Permittee: Scott Lukach  
Apex Waste Solutions  
11681 Progress Lane  
Parker, CO 80134  
(414) 333-3956

**SWMP Preparation Date:**  
October 2024

EPC STORMWATER REVIEW COMMENTS  
IN ORANGE BOXES WITH BLACK TEXT

SHEET # **G.2**

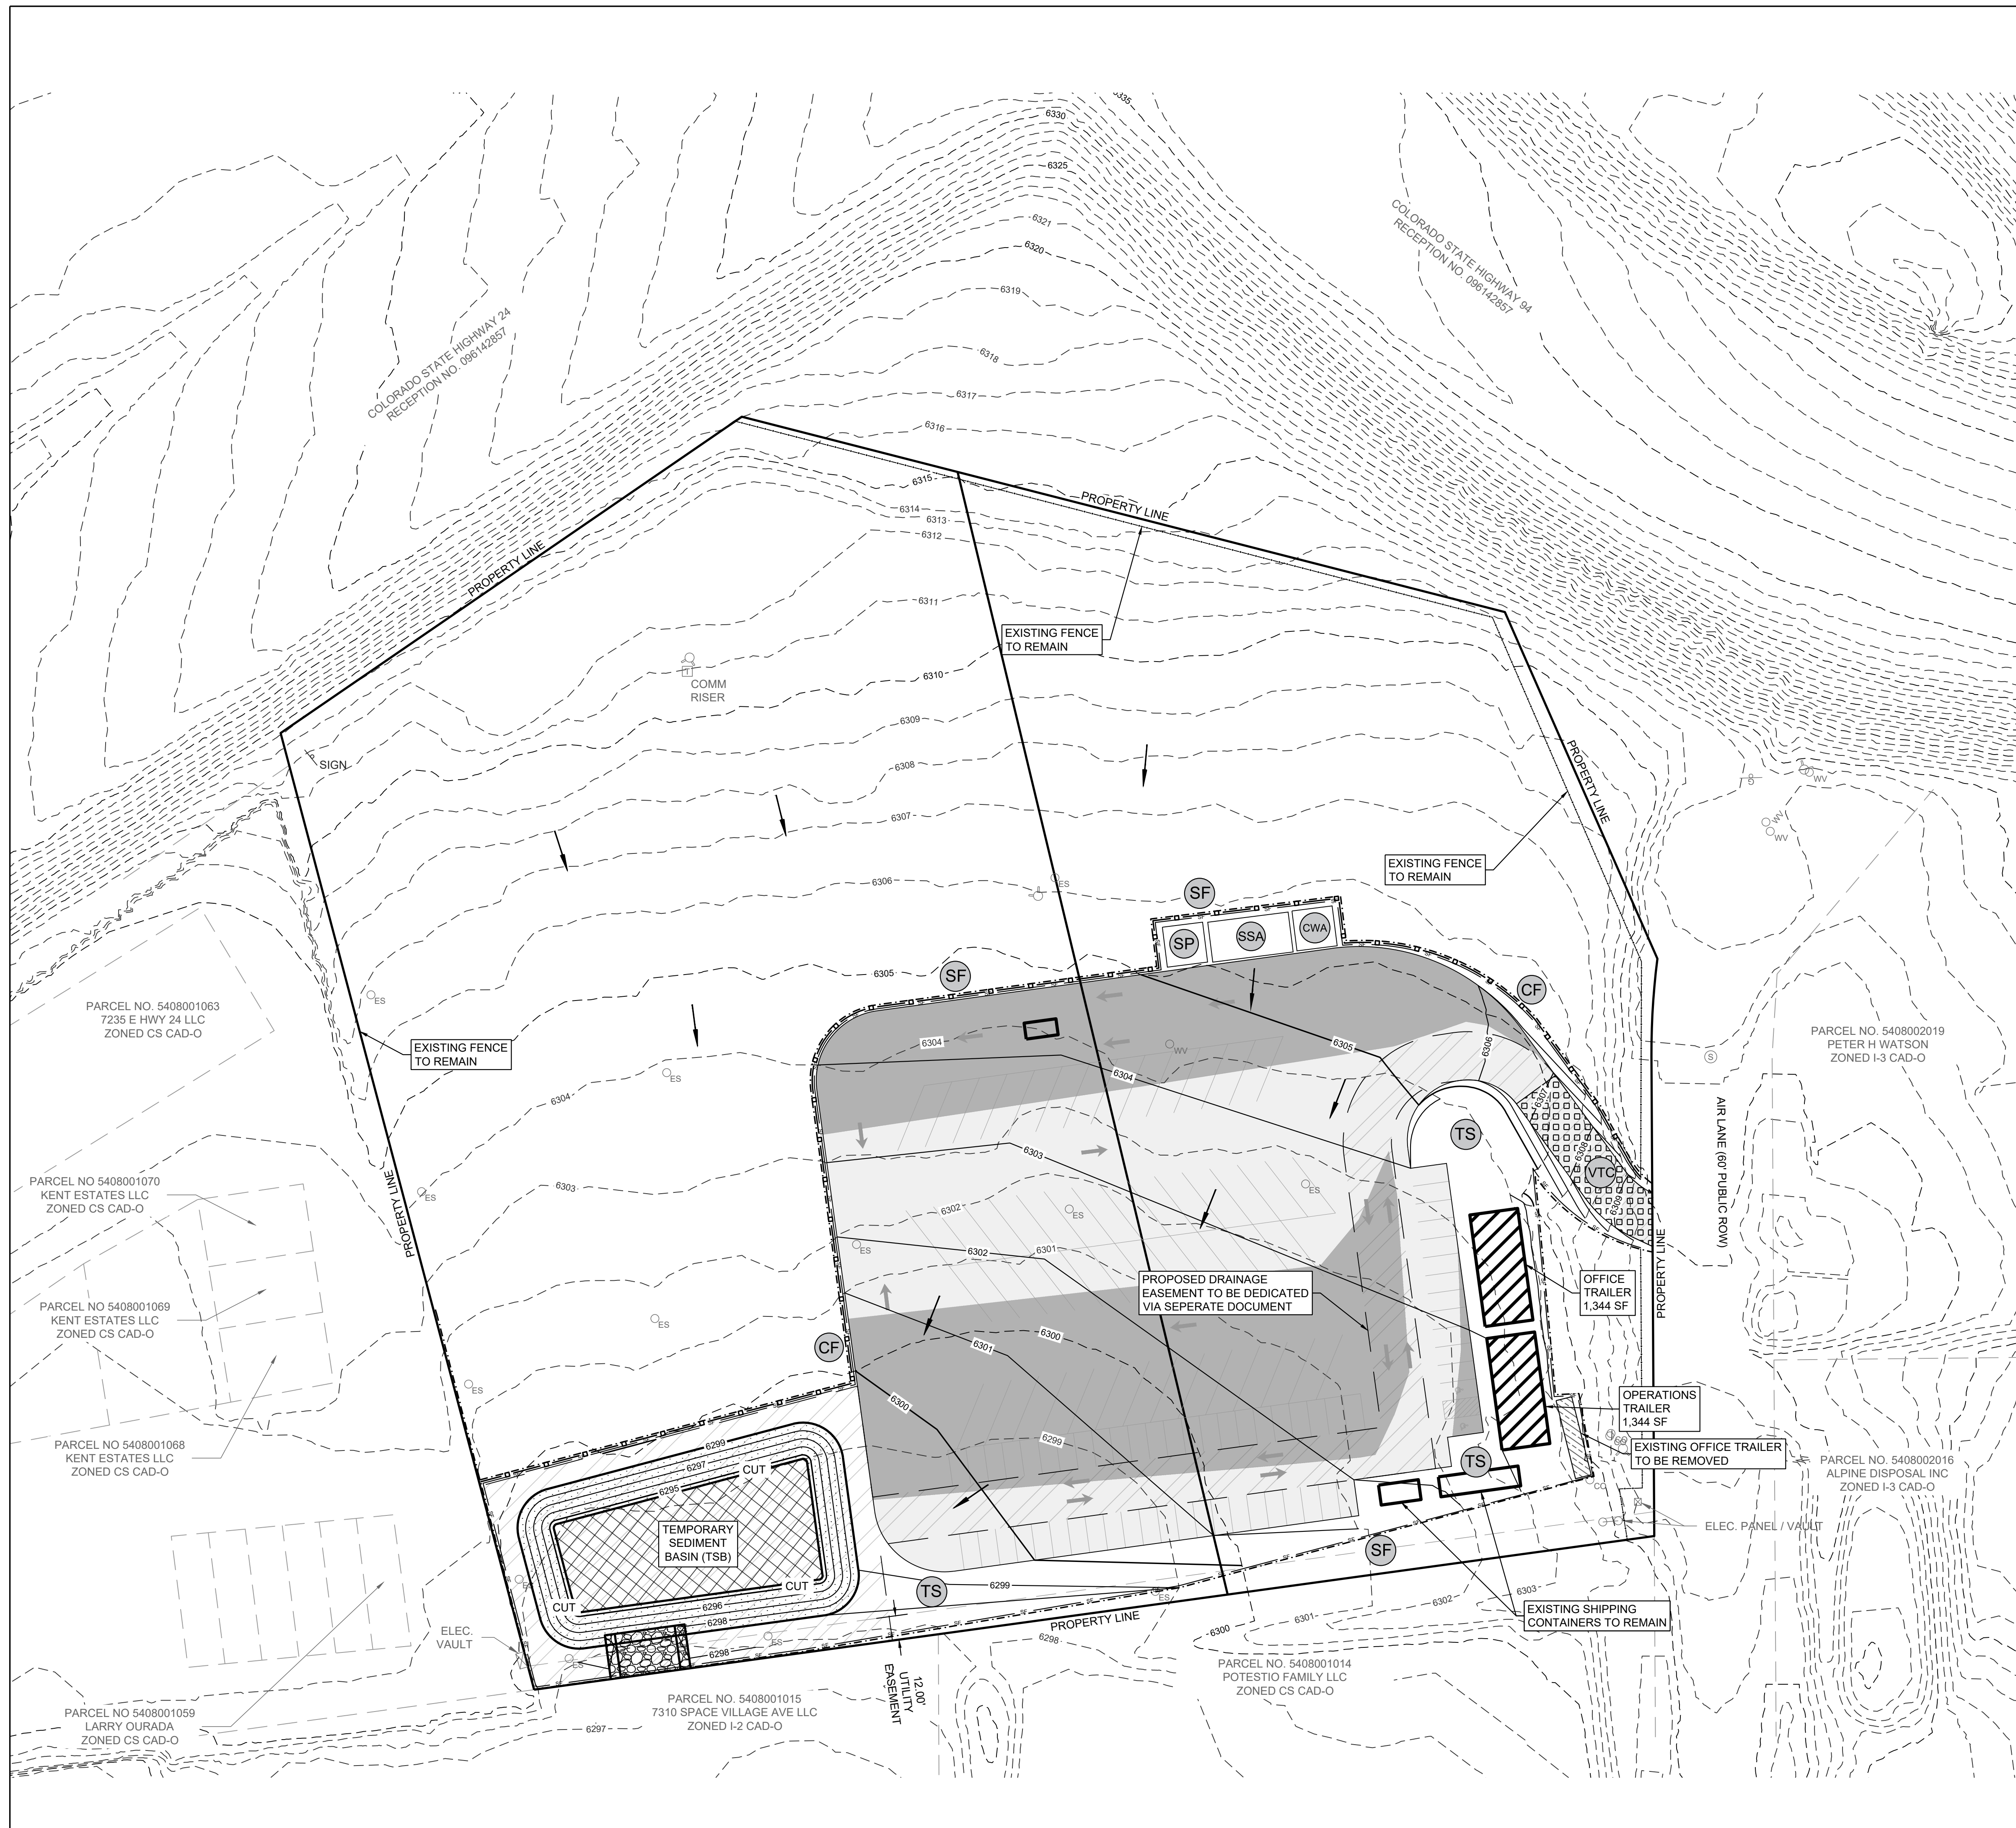
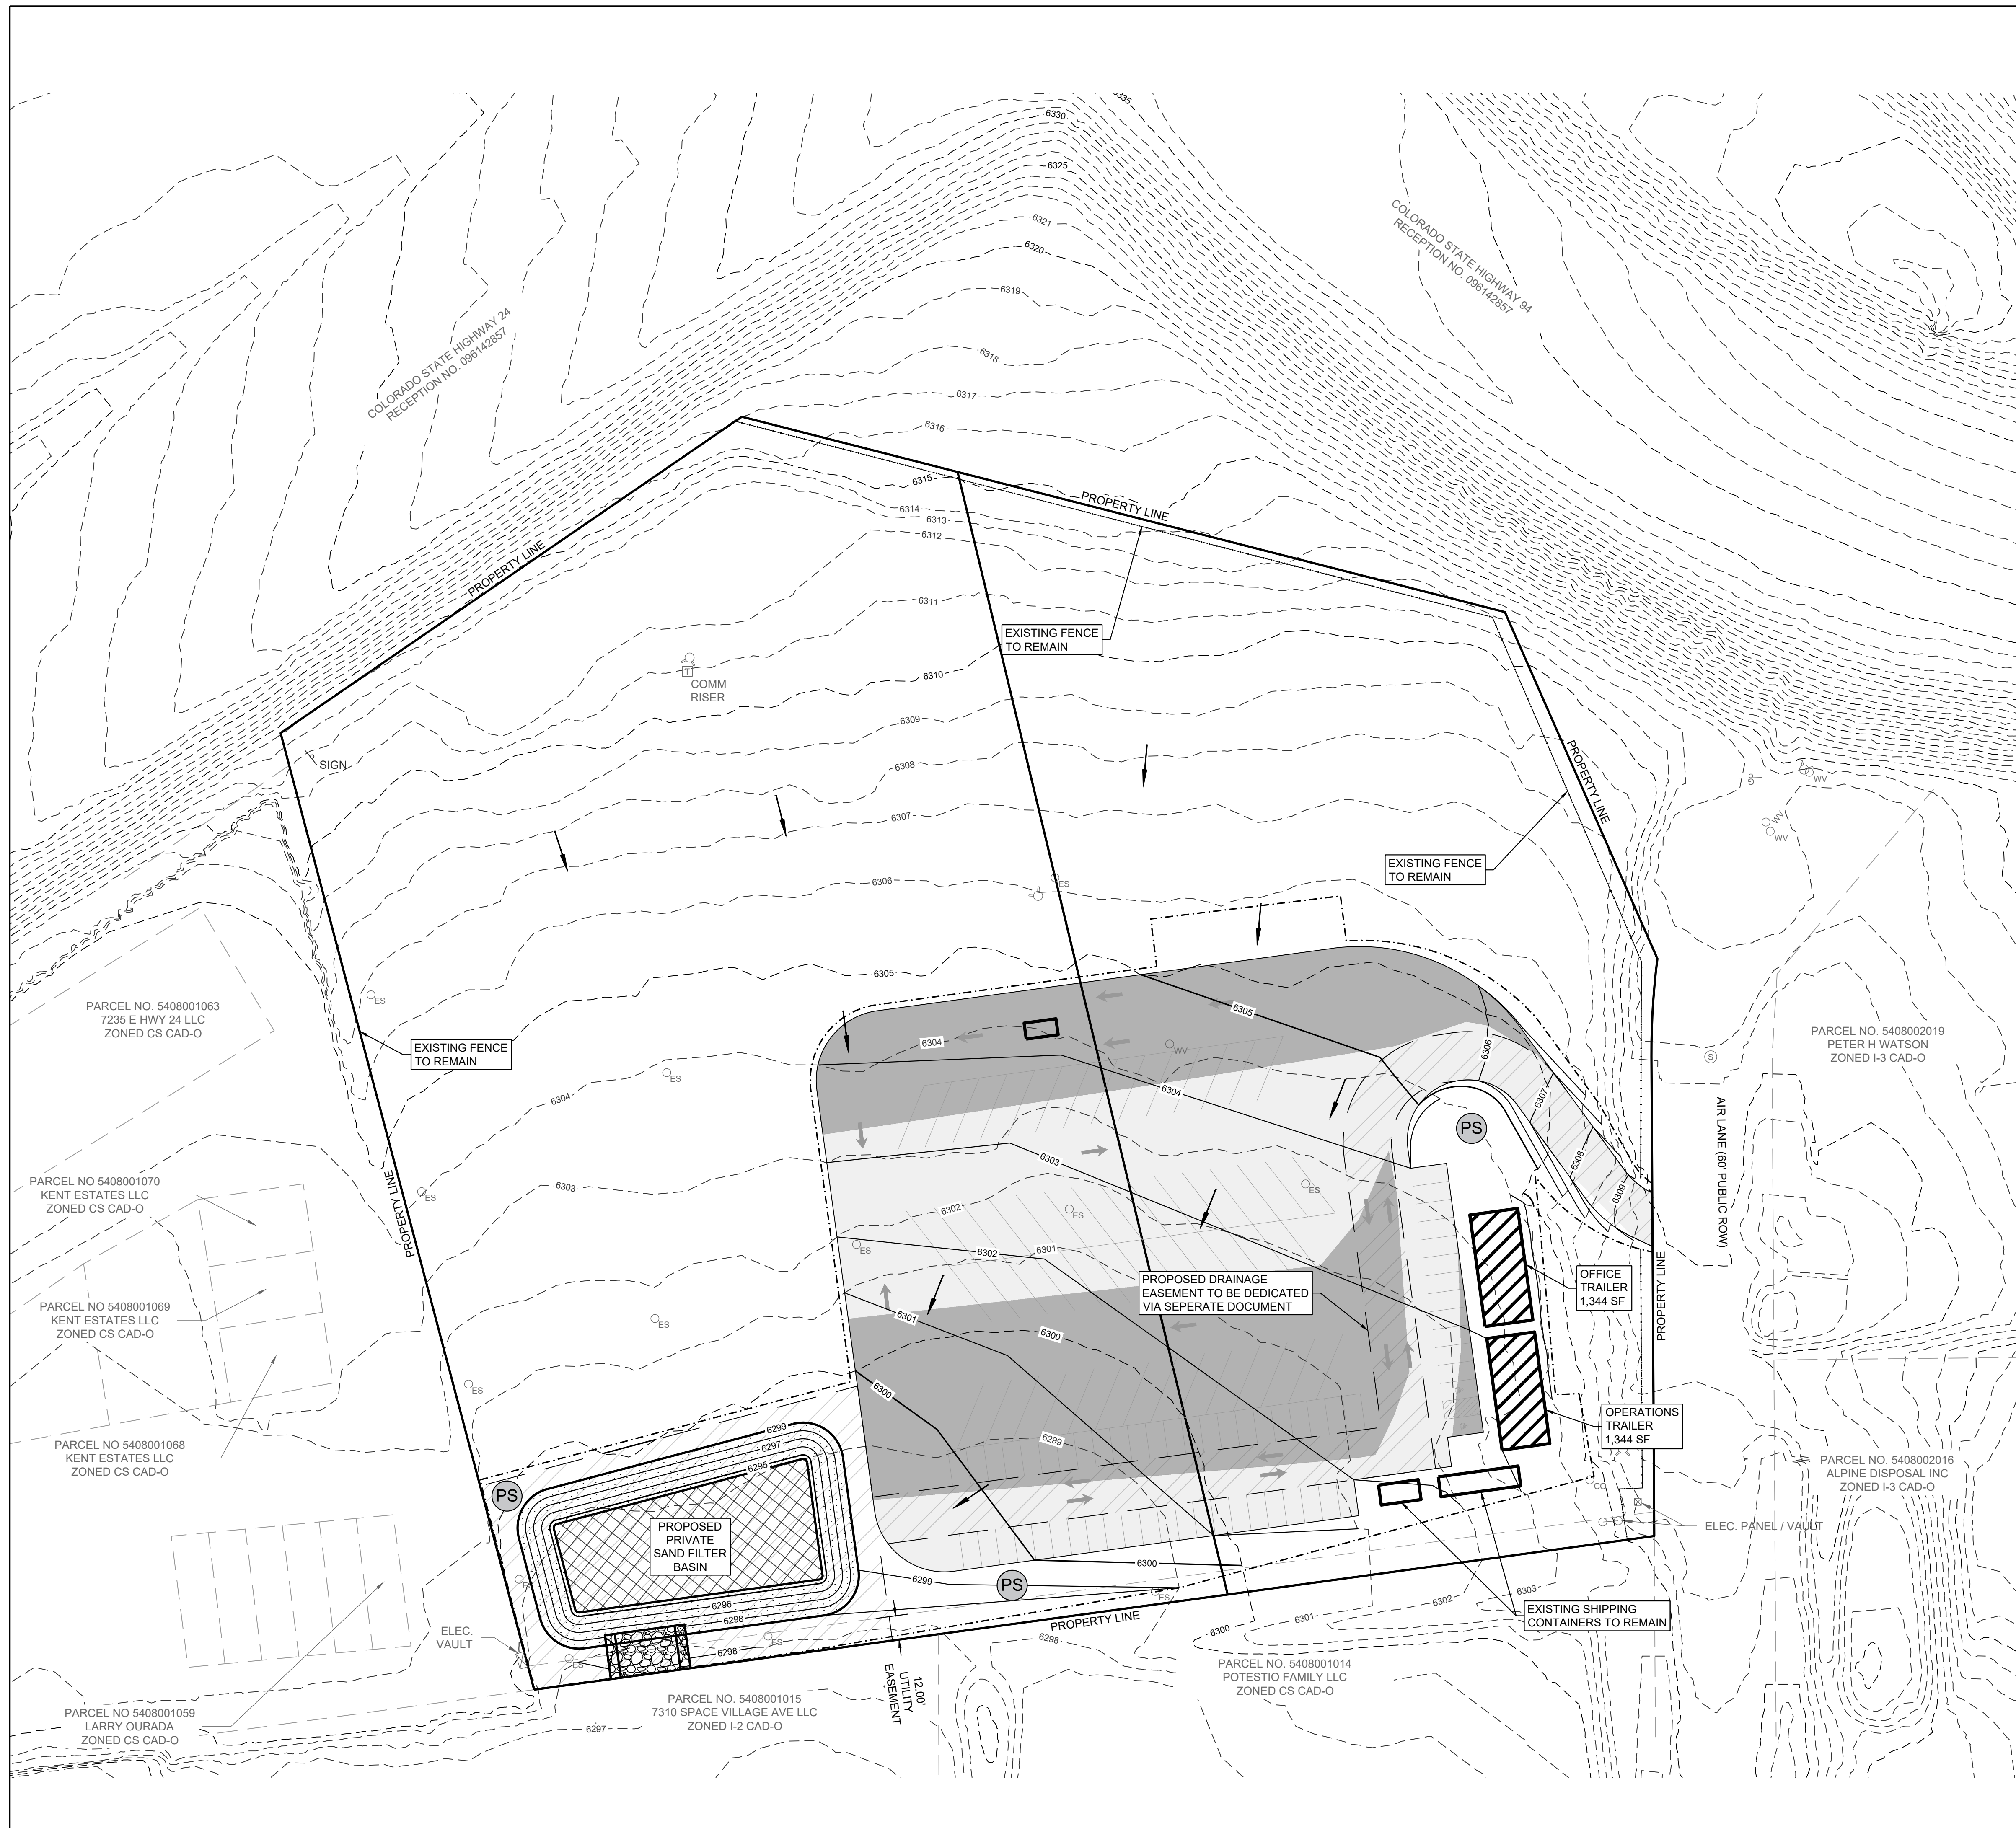
Item 7. Estimated total disturbance does not match acreage of the limits of disturbance as shown on submitted GEC plans.

Item 18. Submitted GEC Plan indicates a TSB will be utilized. Include in structural control measure narrative discussion.
